THE CITIZEN ON CONSTITUTION SITE DEVELOPMENT PLAN

THE CITIZEN ON CONSTITUTION
EL PASO COUNTY, COLORADO
SITE DEVELOPMENT PLAN
OVERALL SITE INDEX PLAN

SHEET  
**C2.1**

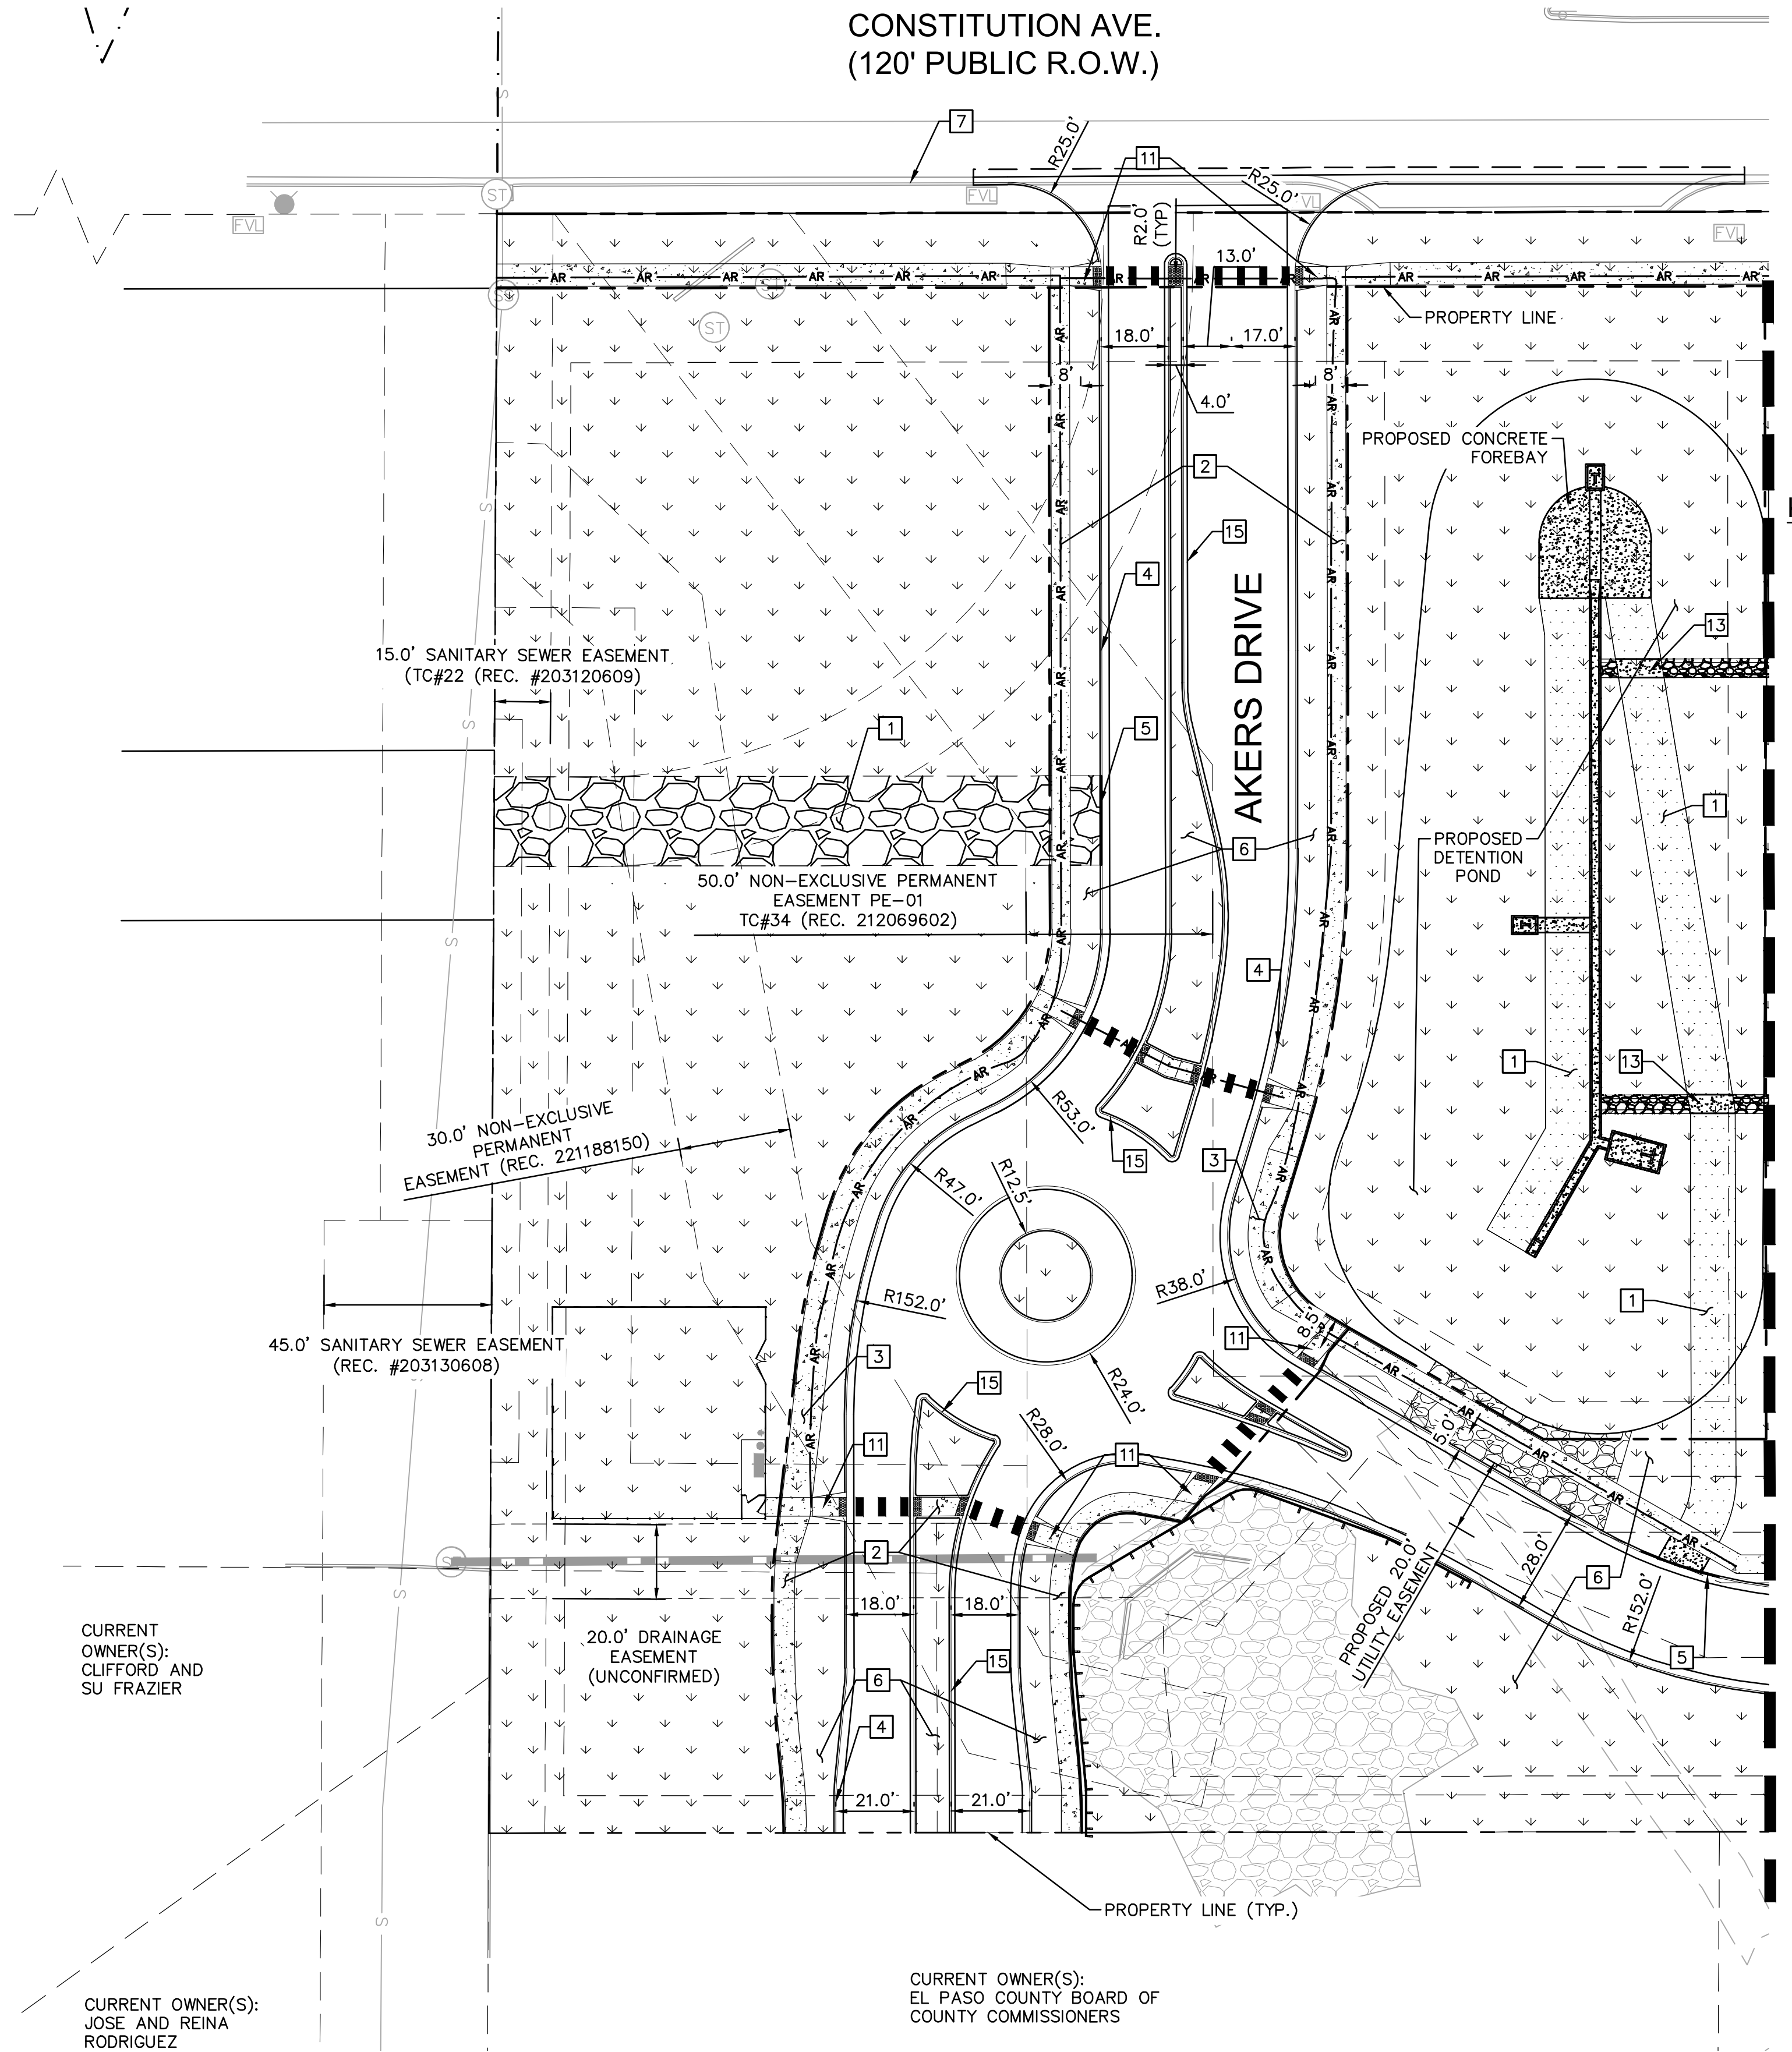
Please refer to any comments provided with the final plat application regarding Akers Drive/roundabout and update the plans accordingly

provide sheet #

THE CITIZEN ON CONSTITUTION
EL PASO COUNTY, COLORADO
SITE DEVELOPMENT PLAN
SITE PLAN (C)

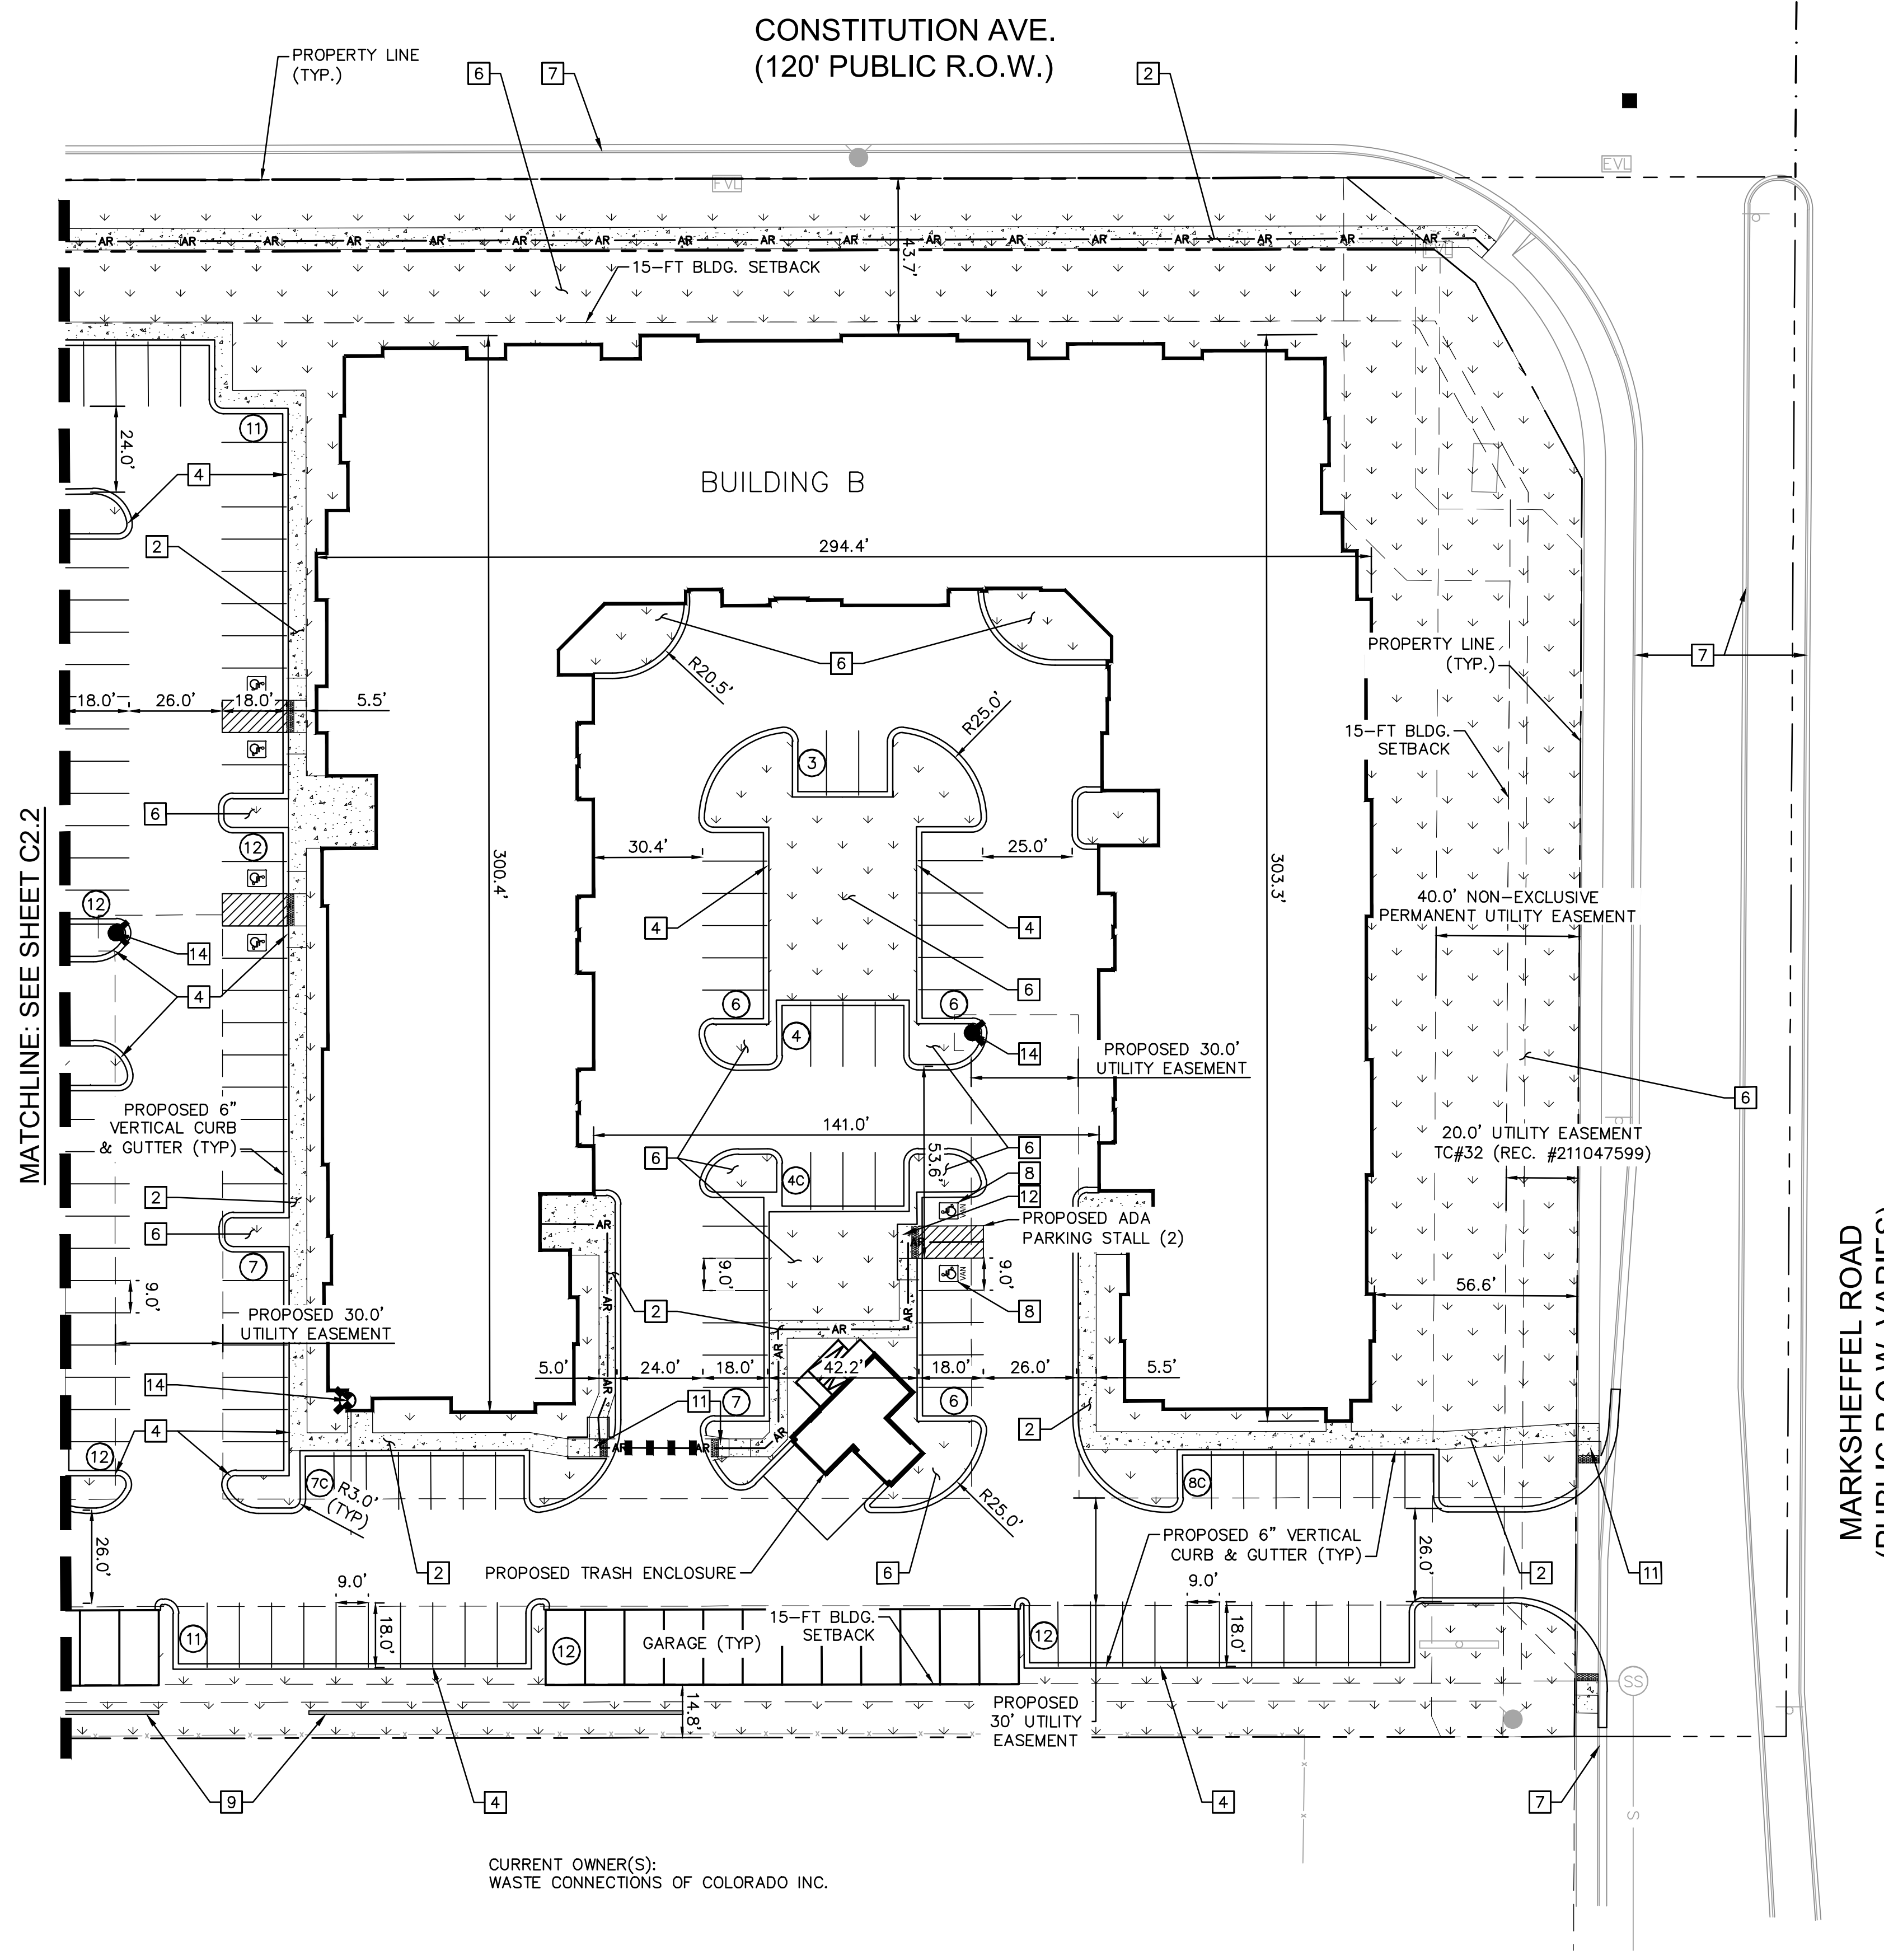
Please revise so the ramps are aligned.
